DRB Application No.: 10DRB-7055 Project # 1003794
Project Name: VOLCANO POINT SHOPPING CTR
Agent: DAT JOSEPH Phone No.:

CITY OF ALBUQUERQUE
PLANNING DEPARTMENT
DEVELOPMENT REVIEW BOARD

10DRB-70155 MAJOR – SITE DEVELOPMENT PLAN FOR BUILDING PERMIT

PAT JOSEPH agent(s) for DOUGLAS PETERSON - PETERSON PROPERTIES request(s) the referenced/ above action(s) for all or a portion of Lot(s) 3, **VOLCANO POINT SHOPPING CENTER** zoned SU-2 FOR PCA (Planned Commercial Area), located on the west side of 98TH ST NW between CENTRAL AVE NW and VOLCANO RD NW containing approximately .7516 acre(s). (K-9)

C2

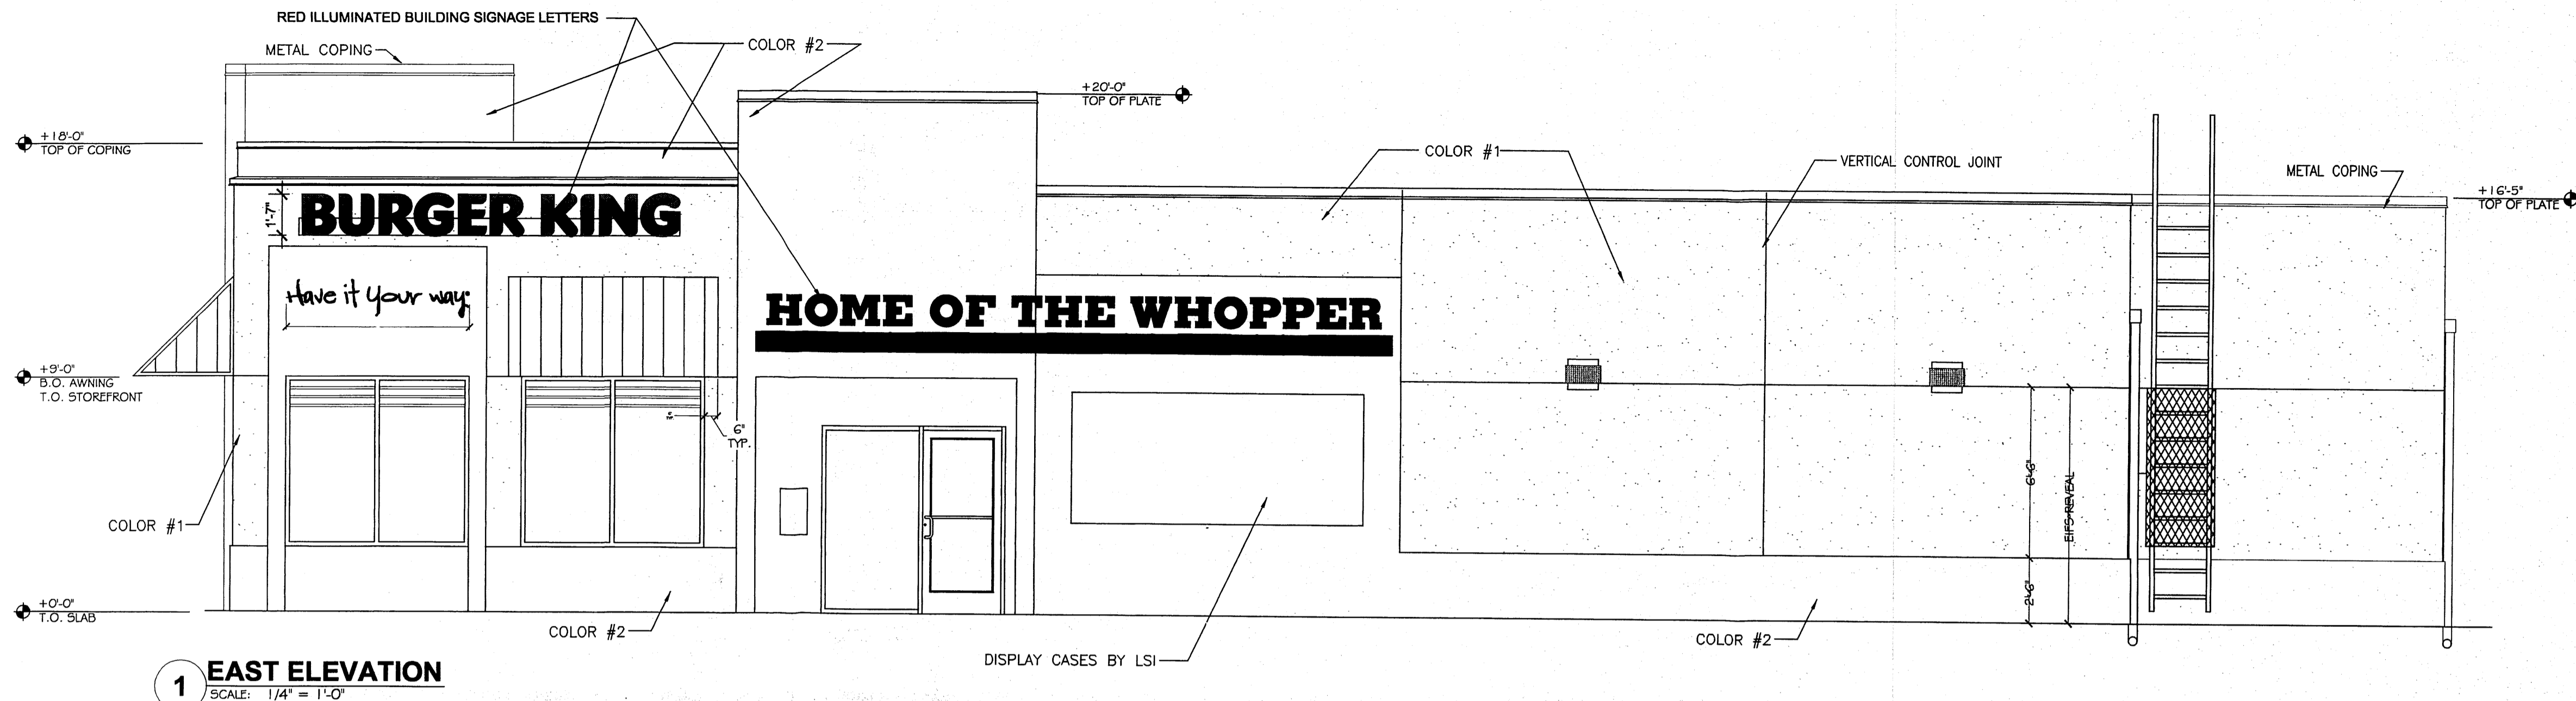
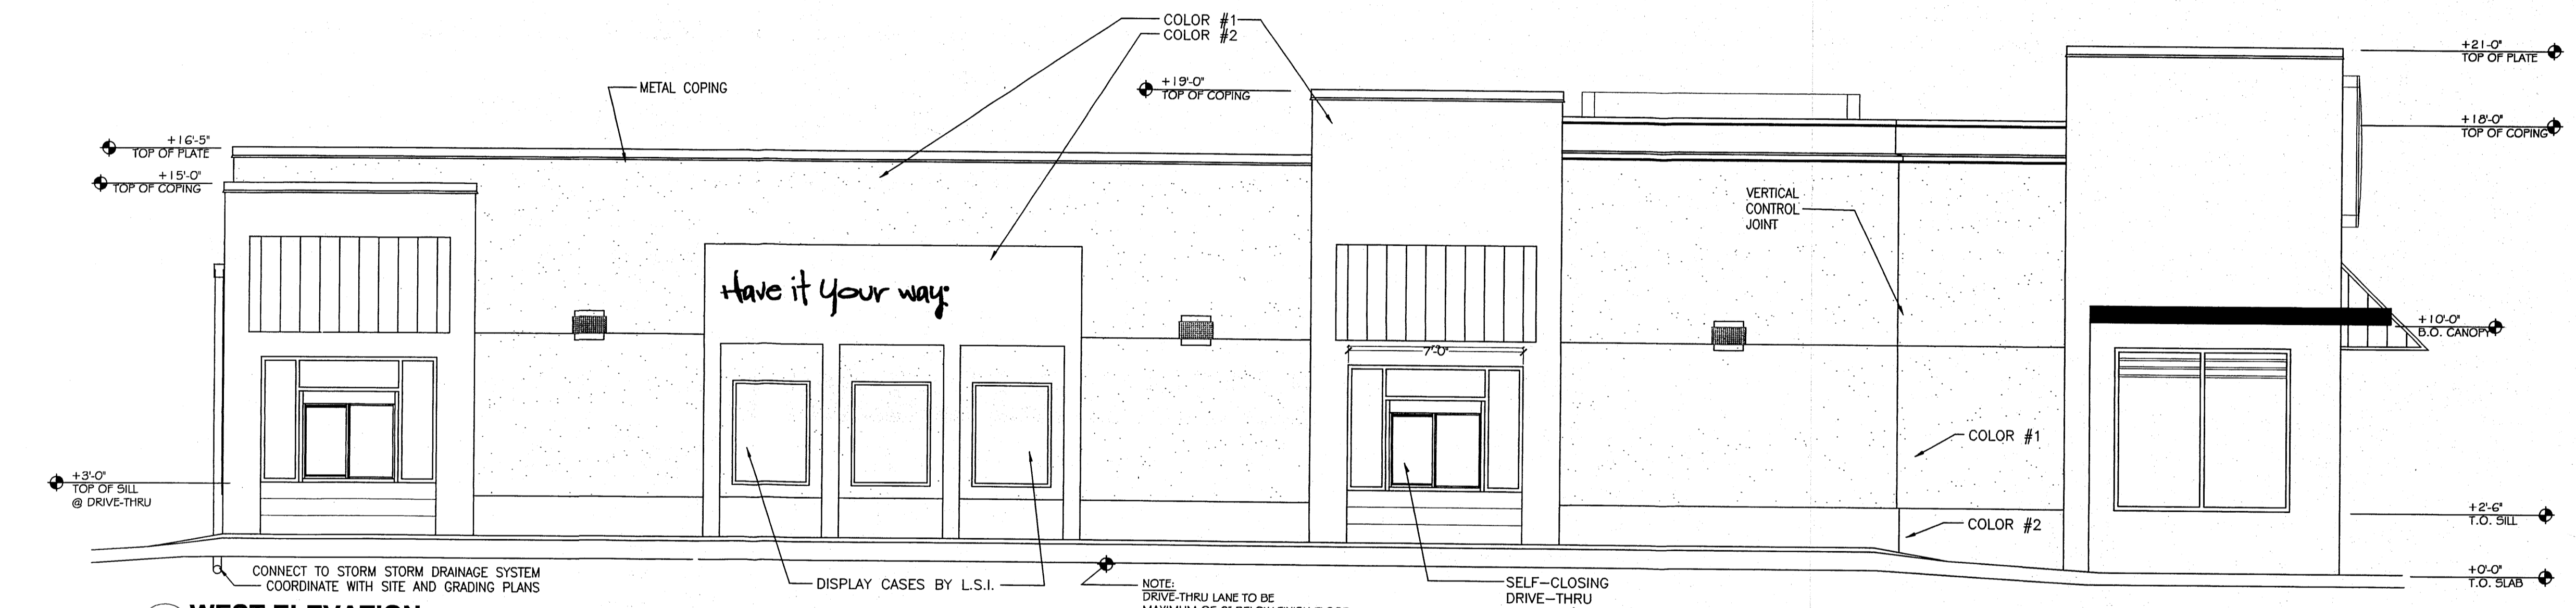
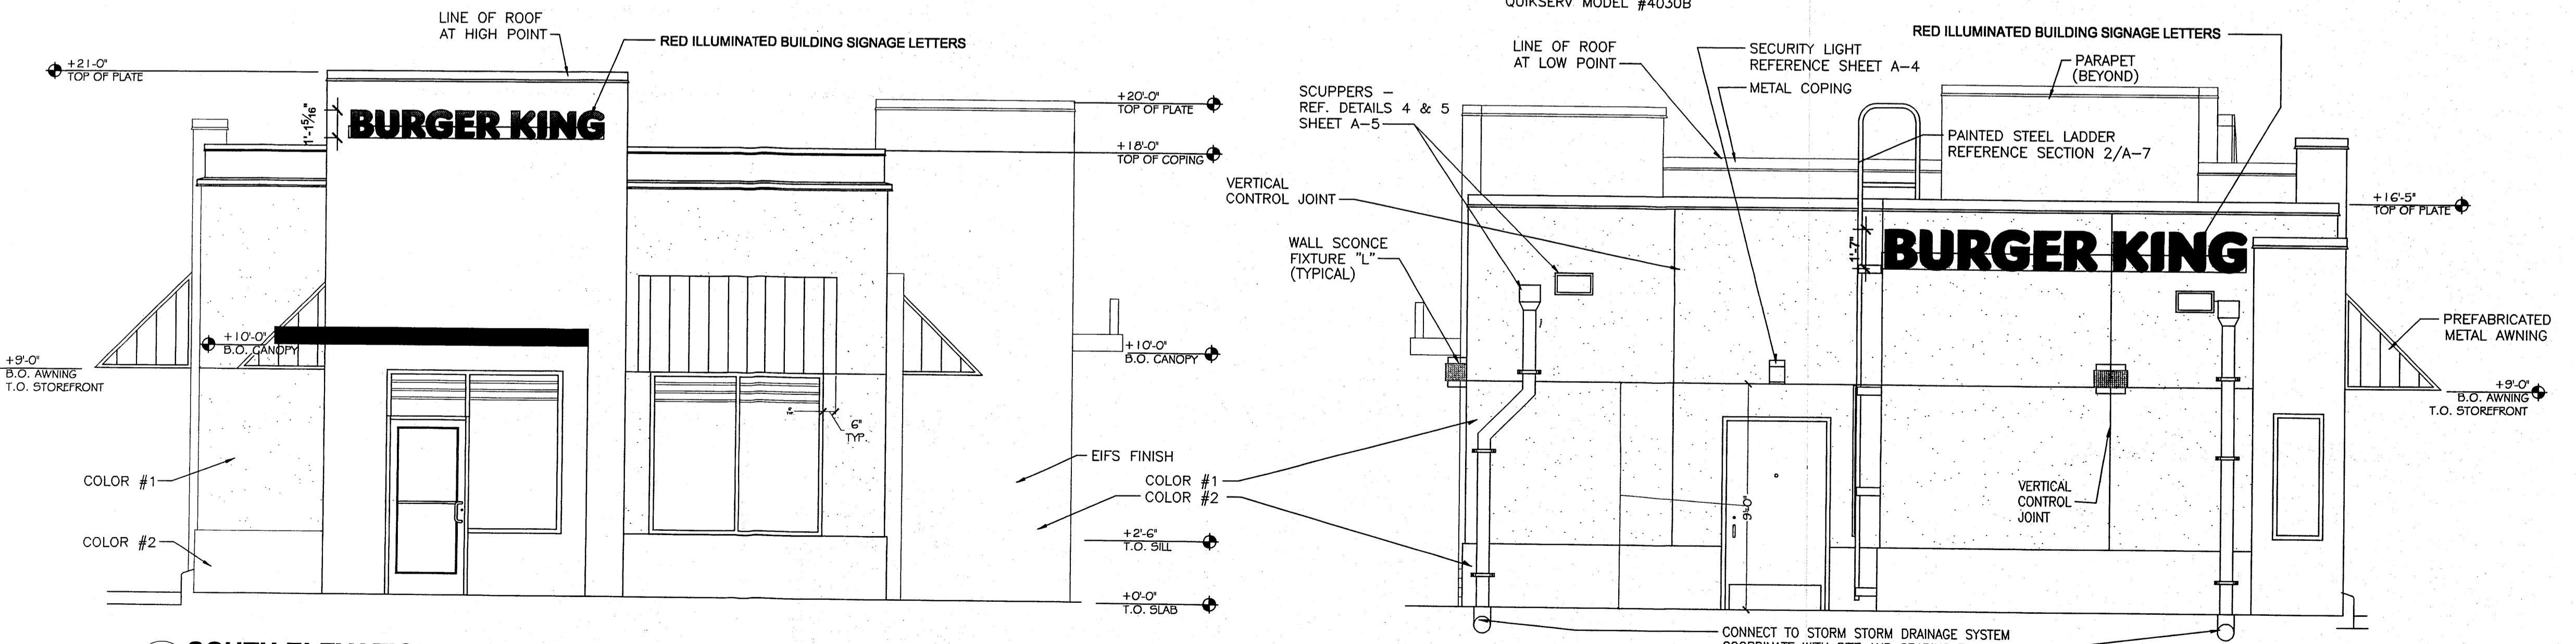
PARKS AND RECREATION No comment.
ABCWUA No comment.
PLANNING DEPARTMENT Sheet AS1 thru AS3 do not need to be part of this final site plan for building permit set. Sheet L1 needs to be replaced with Sheet L2 from Aug 28, 2008 approved site plan. 2 motorcycle parking spaces are needed per Aug 28, 2008 site plan (located at east end of parking row on south side of building). All of Sheet AS2 notations for monument sign needed to be noted on Sheet C3.. More specificity is needed for elevations – refer to Sheet A5.0 from Aug 28, 2008 site plan. Black and Red (as shown on color rendering) are not approved colors per Sheet AS2 – again, refer to Sheet A5.0/ Aug 28, 2008. Building mounted signage material and colors need to be specified.
